Applicant: Ms Emma Wright

Description: Erection 1 no. detached dwelling (Outline seeking approval of layout and means of access)

Site Address: Land adjacent Hay Green Court, Birdwell, Barnsley

Site Plan
1:200

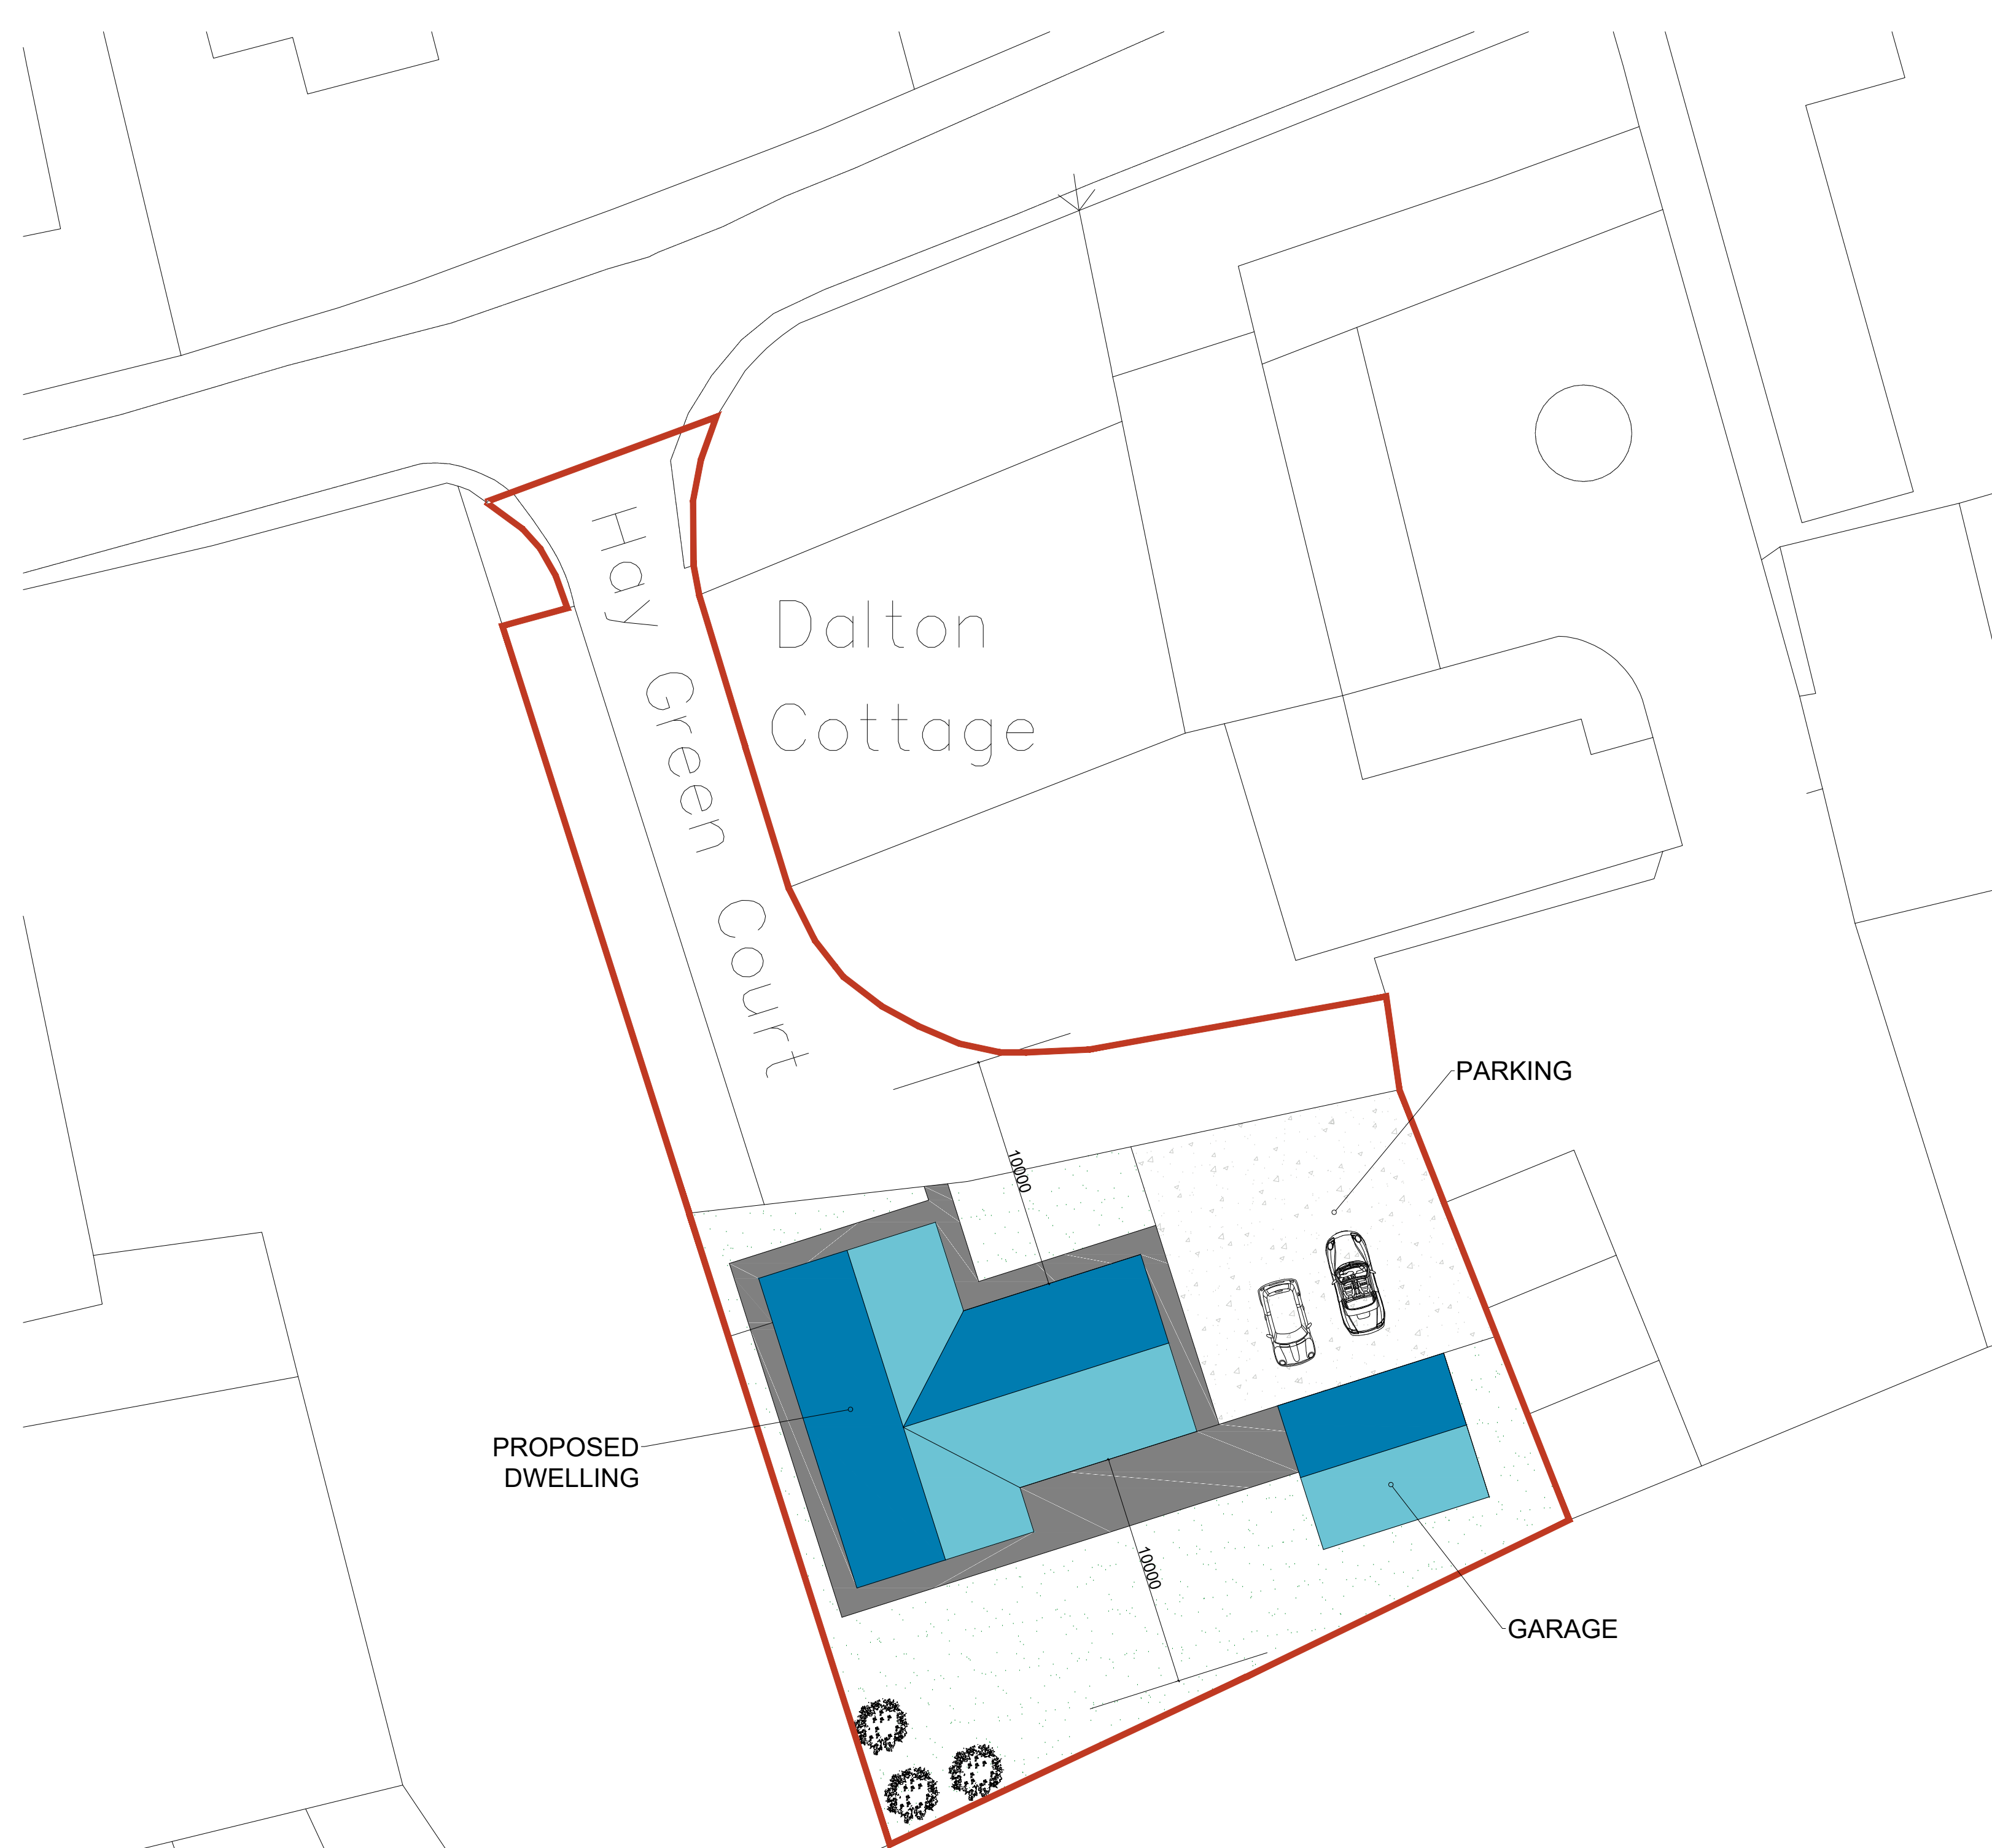
In terms of the layout, the submitted plan demonstrates that the plot can accommodate a detached dwelling with associated detached garage while still providing adequate in curtilage parking and garden/amenity space. However, the proposed footprint of the building is larger than the footprints of the immediately adjacent 2 storey dwellings, as such, if a fully 2 storey dwelling came forward on that footprint it would unlikely be supported as it would not reflect the development pattern or the scale of the area. A single storey dwelling on that footprint would be more likely to be supported (subject to meeting the relevant policies and guidelines at reserved matters stage), as such, a condition will be recommended for the future dwelling to be single storey.

However, layout is to be considered and a site/layout plan has been provided. The proposed dwelling would be positioned to the South West of the existing dwellings within the gated development and would be separated from them by Hay Green Court. Although the scale of the dwelling would need to be considered further at reserved matters stage, the layout demonstrates a dwelling could be accommodated on the site without significantly increasing overshadowing or being an overbearing feature.

To the south of the site a detached dwelling has been approved within close proximity of the rear boundary. However, the proposed dwelling would be orientated to the North of this dwelling and would not result in unreasonable overshadowing or be an overbearing feature. The plan also shows that a separation distance of circa 12m could be achieved between the proposed rear elevation and the approved side elevation, as well as a distance in excess of 10m from the proposed rear elevation to the approved private garden spaces, in accordance with the SPD. There is also a distance of at least 10m from the proposed front elevation to the private amenity spaces serving the dwellings in the gated development.

No details of internal spacing has been provided and this will be assessed further at reserved matters stage, although the submitted layout plan does demonstrate a private amenity space of over 60m² can be achieved, in accordance with the SPD.

The layout plan demonstrates at least 2no. off street parking spaces can be located within the curtilage of the dwelling which would be in addition to any space created

The plan also shows that the development would share Hay Green Court with the existing residents and the total number of dwellings served by that driveway would not exceed 5. There is also adequate turning and manoeuvring space to allow vehicles to enter and exit the site in a forward gear.
